Re: PROPOSED EXTENSION TO THE JOLLY CRISPIN P.H. MARRIOTS GATE LUTTON
FOR MR M E BUNN

Description: Details of acoustic fencing,
landscaping and car parking
(Conditions 3, 4 and 6 of
H12/0111/95)

Amendment: Details of car parking arrangement changed to allow grey
alder tree to remain (drawing number 771805/4)

Amendment: 1.8 metre high fence to southern boundary
(drawing number 771805.4)

NOTES
WINDOWS TO FUNCTION ROOM TO BE DOUBLE GLAZED TO REDUCE NOISE ESCAPING TO THE OUTSIDE

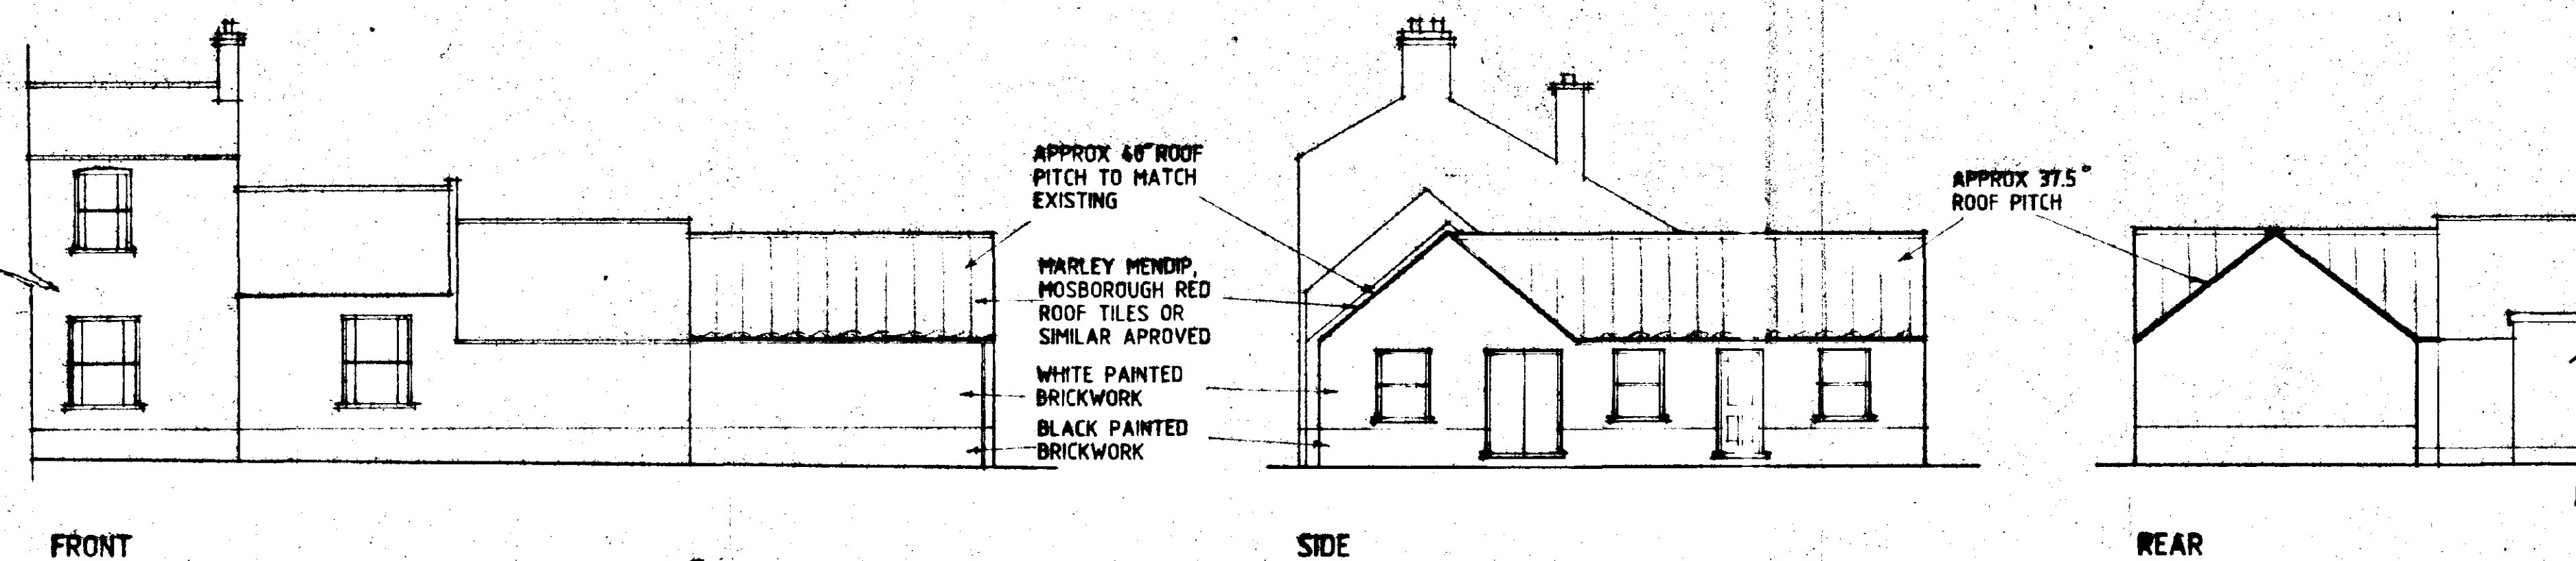
Carparking arrangement changed
to allow grey alder tree to
remain

In respect of your letter dated 9th August 1995, I enclose 4 no. copies of amended drawing no. 771805/4 showing car parking arrangements adjusted to show grey alder tree to remain as required.

1.8m high fence to southern
boundary

Further to your letter dated 10th November 1995, I enclose 4 no. copies of revised drawing no. 771805/4 showing fence to the southern boundary as required together with duly completed Planning Amendment forms.
